# CITY OF ALBUQUERQUE

July 23, 2020

**RE: Albuquerque School of Excellence  
13201 Lomas Blvd. NE  
Revised Grading & Drainage Plan  
Engineer's Stamp Date: 07/20/20  
Hydrology File: J22D050**

RE: **ALBUQUERQUE SCHOOL OF EXCELLENCE  
13201 LOMAS BLVD NE  
REVISED GRADING & DRAINAGE PLAN  
ENGINEER'S STAMP DATE: 07/02/20  
HYDROLOGY FILE: J22D050**

ENGINEER'S SEAL	DRAWN BY pm
	ABQ SCHOOL OF EXCELLENCE	DATE 11-5-19
	OVERALL GRADING AND DRAINAGE PLAN	DRAWING 2019068-GR
	 5571 MIDWAY PARK PL NE ALBUQUERQUE, NEW MEXICO 87109 (505) 858-3100 www.tierrawestllc.com	SHEET # GR-1 JOB # 2019068

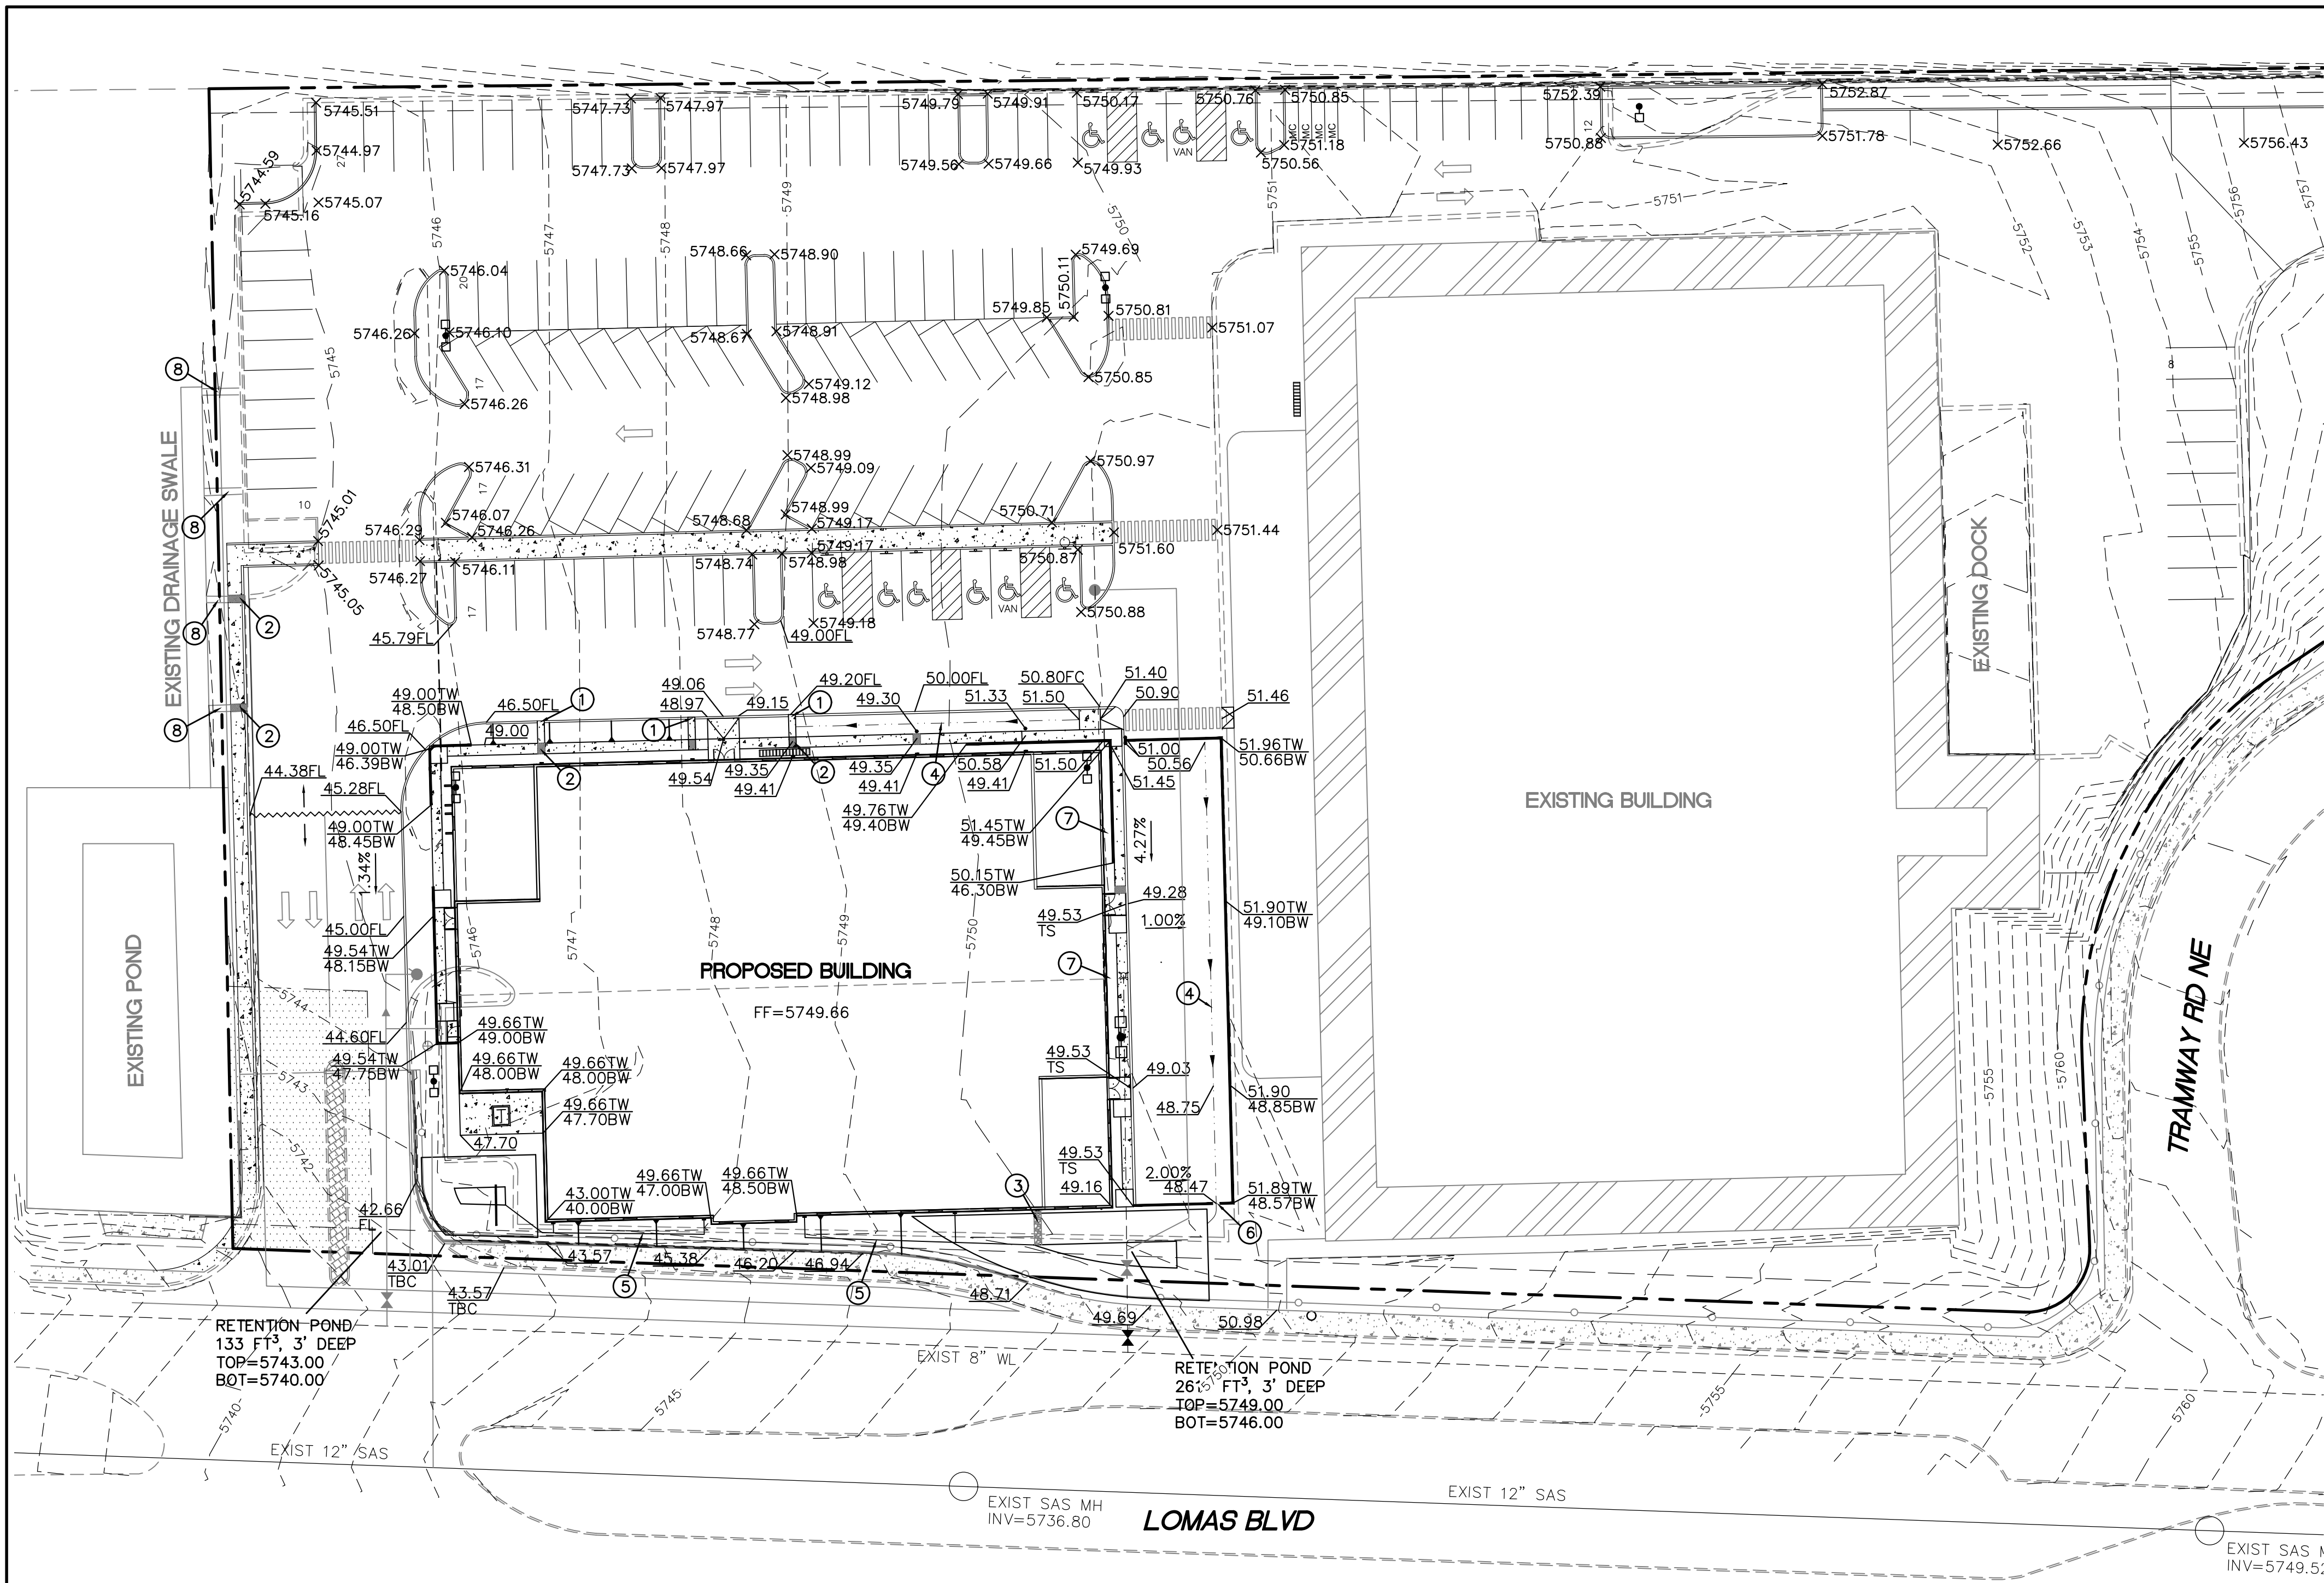
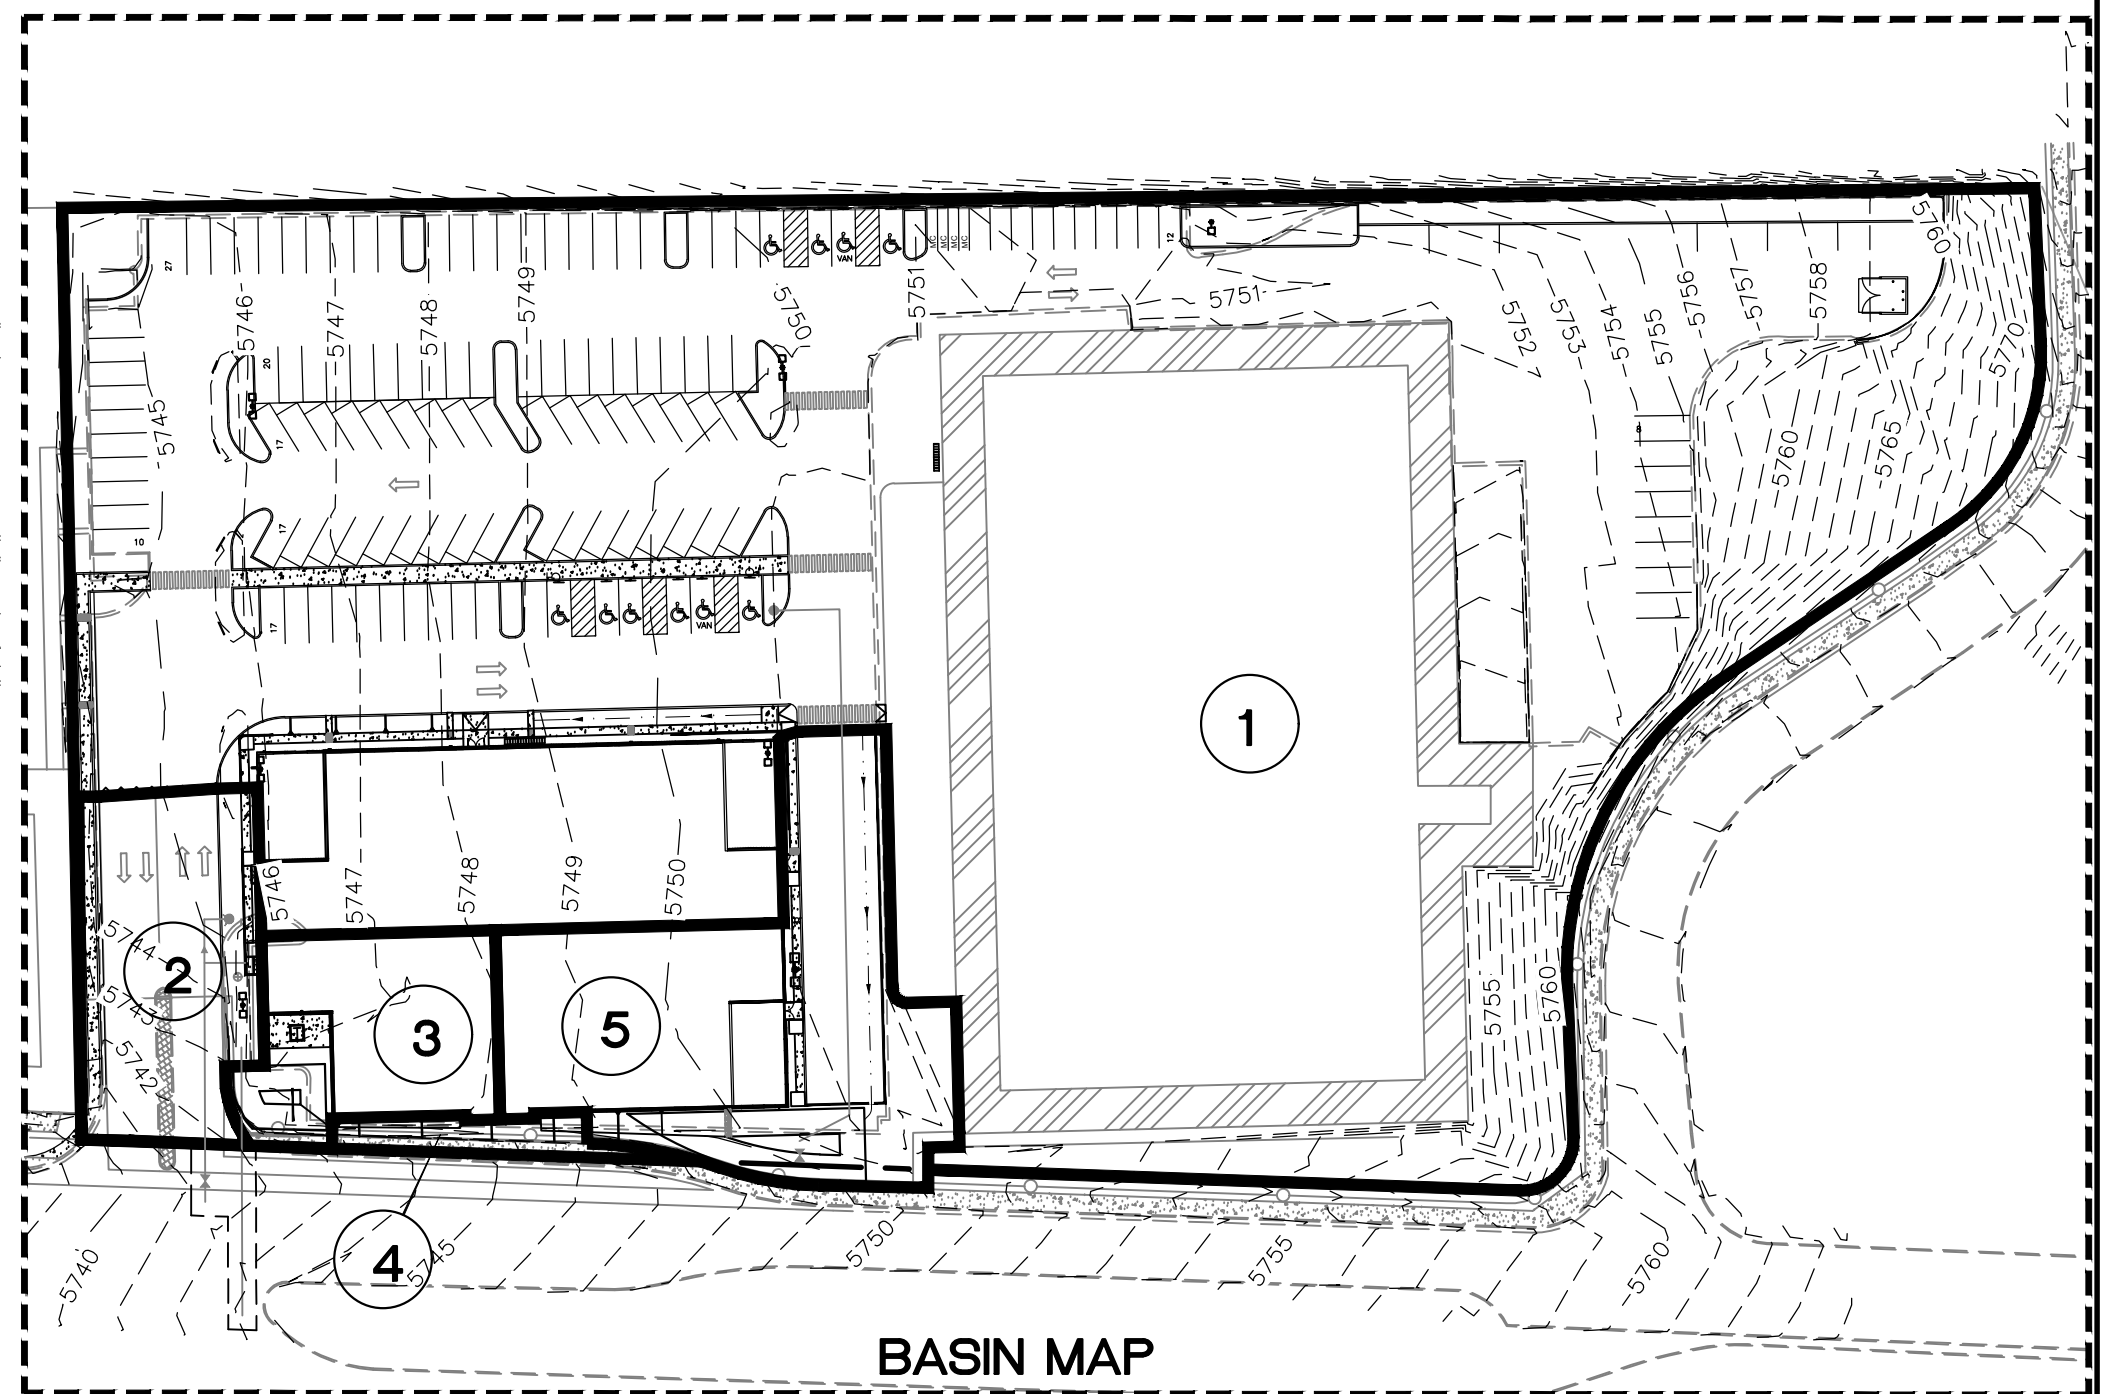
1. Sheet GR-1 almost all the line work is the same line weight, so I can't tell what existing items are and what proposed items are. Please correct the proposed items with a darker line weight. **The proposed revisions are to the entire parking lot area. The line work was darkened up to help illustrate the new improvements and the area was bubbled.**

2. Sheet GR-1 this goes with the first comment. Are all the paving new or is there going to be paving that is to remain? If there is paving to remain, then there needs to be a break line. **The entire parking area will be repaved.**

3. Sheet GR-1 it is hard to tell where Pond A and Pond B are located. Please provide a top of pond outline (contour) and a bottom of pond outline (contour) **The Ponds are now shown with darker lines and called out with notes.**

4. Sheet GR-1 please provide an emergency spillway for both retention ponds by way of sidewalk culverts. The elevation of the sidewalk culverts should be the 100 year – 10 day WSE. **A sidewalk culvert was added to Pond "A" that daylights to Lomas and a 2' curb opening was provided to Pond "B" that daylights to the drive aisle. Both are sized to handle the 100 year flow.**

5. Sheet GR-1 please us the latest SO-19 notes (see attachment) **The latest SO-19 note was added to the plan.**
6. Sheet GR-2 all sections please correct the location of the Property Line / ROW. This is shown correctly on Sheet GR-1. Within the ROW should be the sidewalk (at the ROW line) the curb and the roadway. **All of the cross sections were updated and corrected.**
